Essex County Council's response to the Secretary of State second consultation dated 20 November 2023

Thank you for consulting Essex County Council (the Council) and requesting for our comments on item 10 and 12 of the second consultation letter in connection with National Highways' application for development consent for the proposed A12 Chelmsford to A120 Widening Scheme.

C:\pwworking\jacobs_uk_highways_s4\elnourad\0155545\HE551497-JAC-LDC-SCHW-DR-C-0314.dwg - 25/05/2023 16:12:57 - A1 Frame - ElnourA

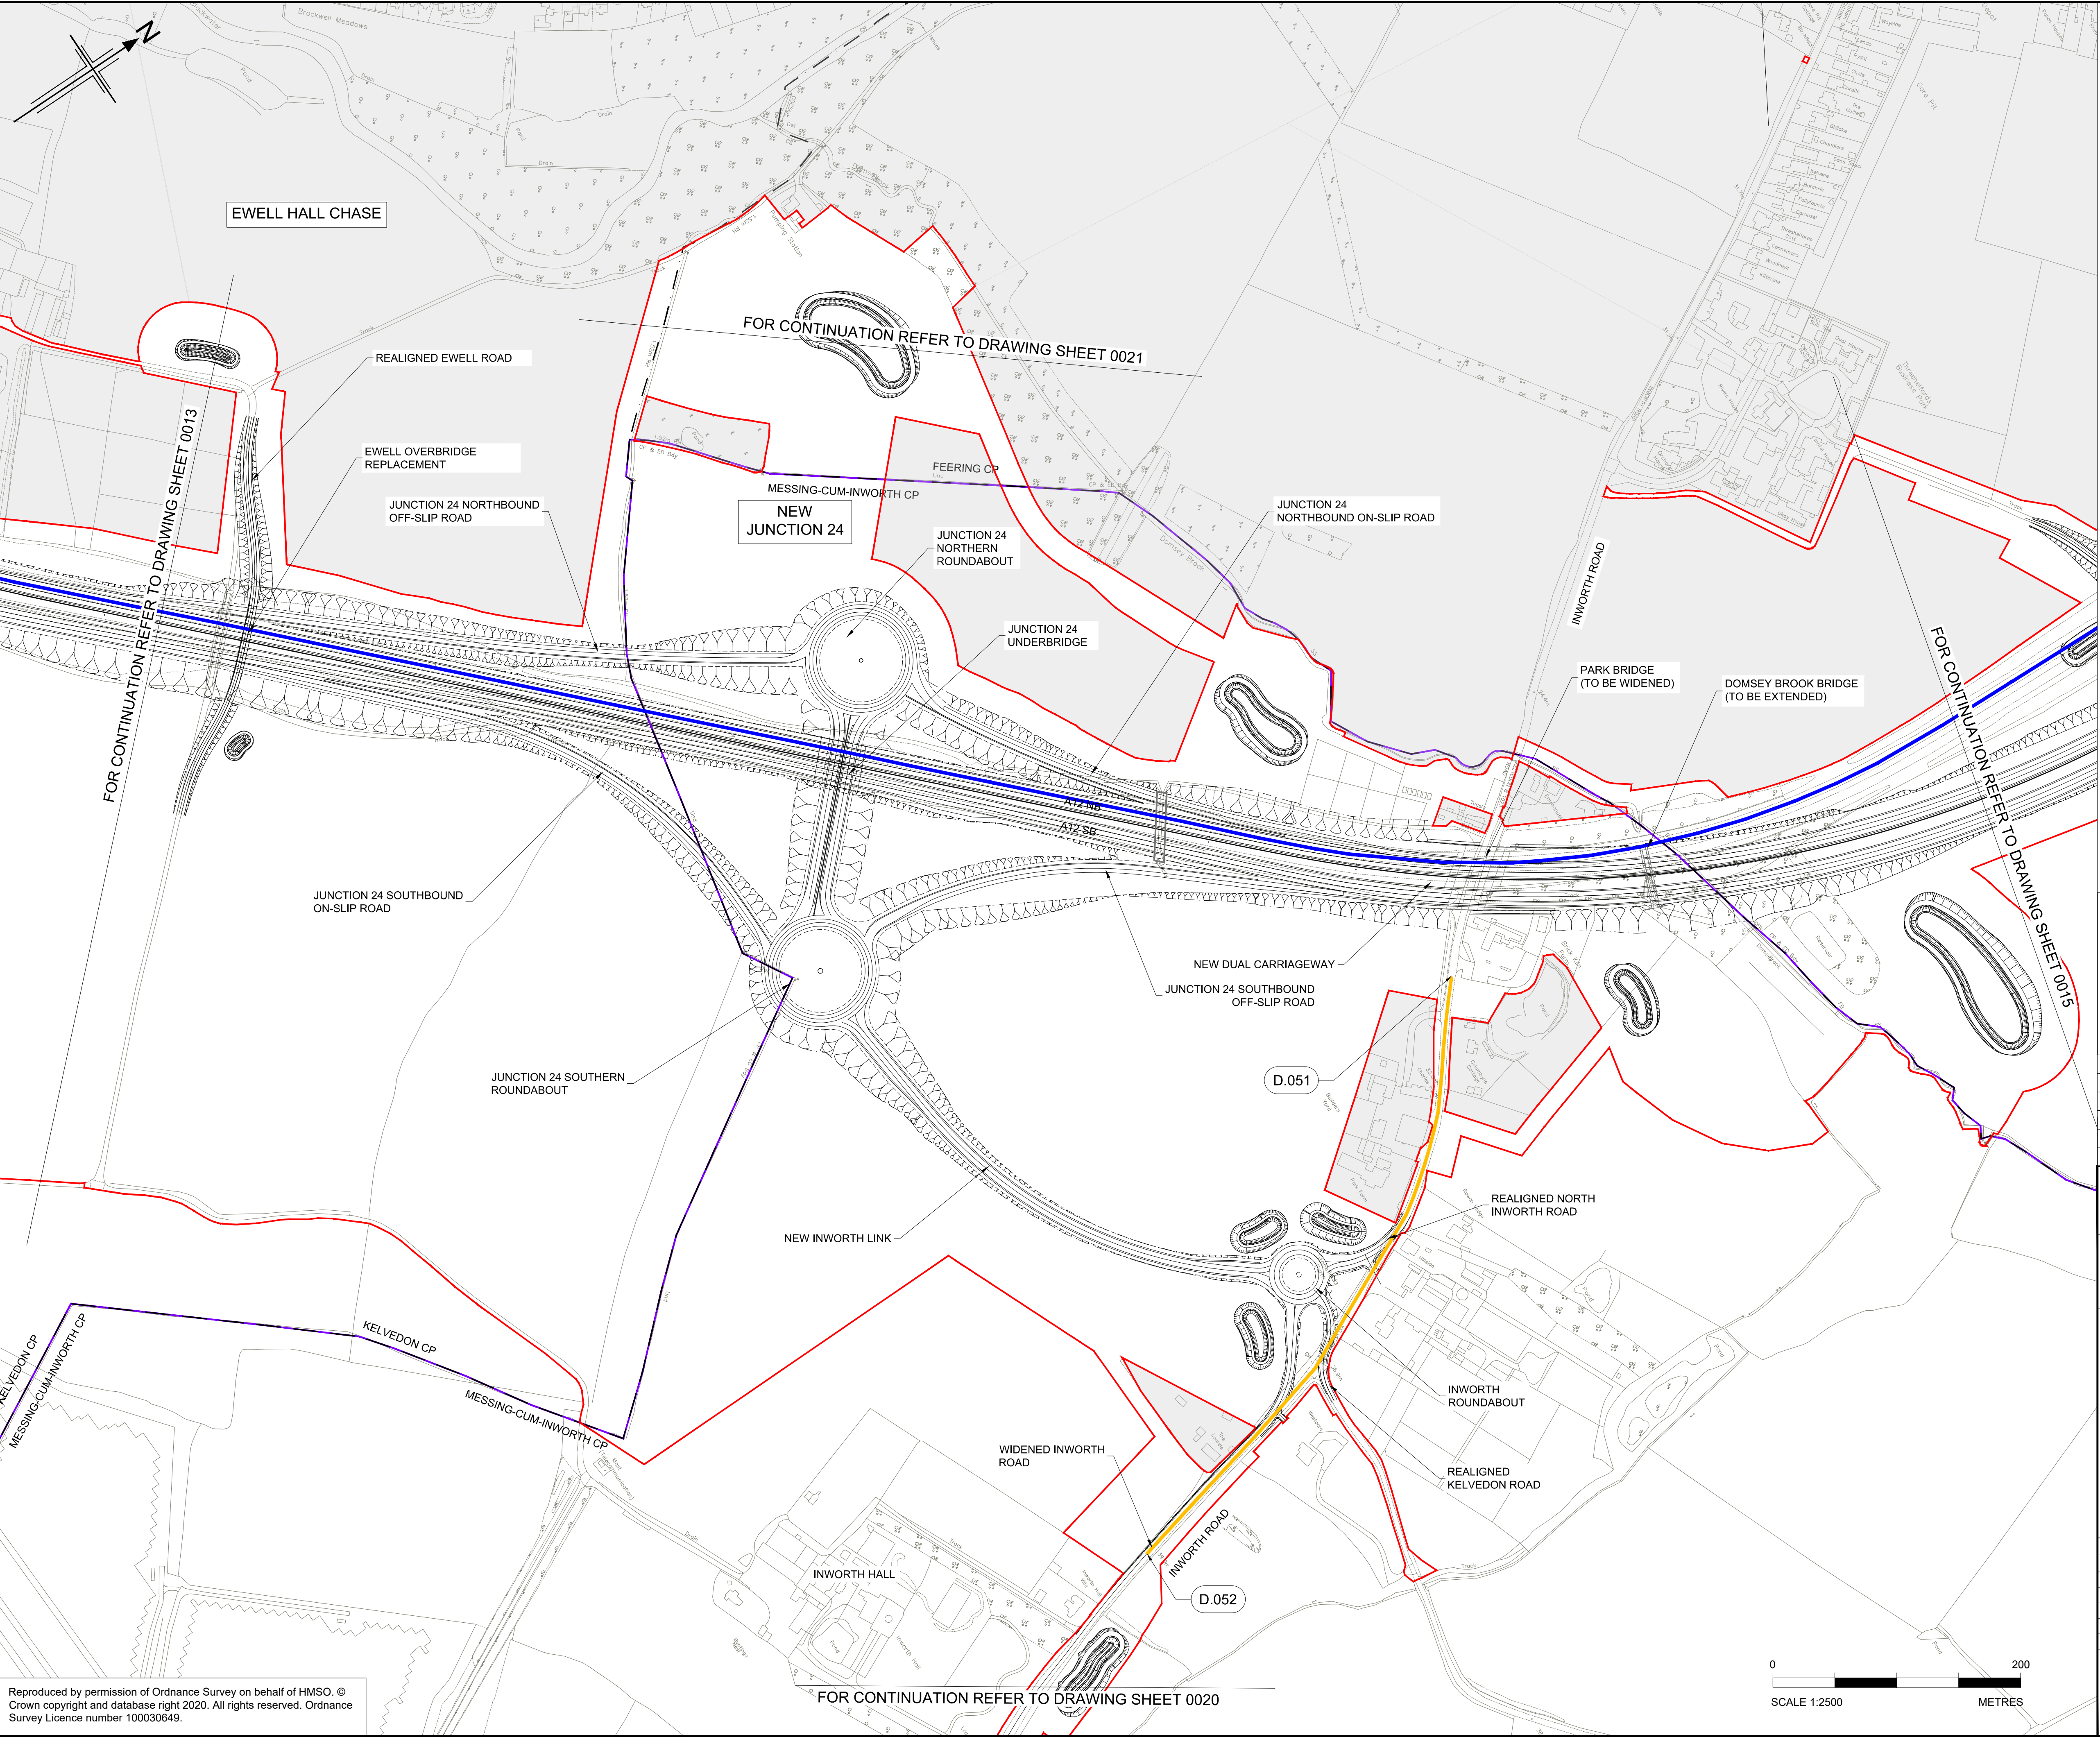
Messing- cum- Inworth CP	A12 Junction 24 underbridge (southeastbound side), from point A.137, 6 metres north west of the centre point of the junction 24 southern roundabout to point A.138, 6 metres south east of the centre point of the junction 24 northern roundabout, a distance of 165 metres.	Removal of restricted road status	This road forms part of the SRN maintainable by the Applicant and is the responsibility of the Applicant to specify an appropriate speed limit
Copford CP	New Wishingwell Bridge Road (both sides) from point A.079, 16 metres south of the centre point of the Wishingwell Farm roundabout to point A.080, 83 metres south of the same point, a distance of 67 metres.	Removal of restricted road status	NSL

- c. Inworth Road Roundabout – The Council’s response to REP3-012 is documented in REP4-075 Page 22, where we outlined our case why the adoption of local road standards isn’t appropriate. As a result, we maintain the view that additional measures proposed in the Council’s Inworth, Messing & Tiptree Mitigation Options Technical Note [REP3-033] is required to mitigate the impact of the traffic flow changes in the vicinity of Messing, Inworth and Tiptree.
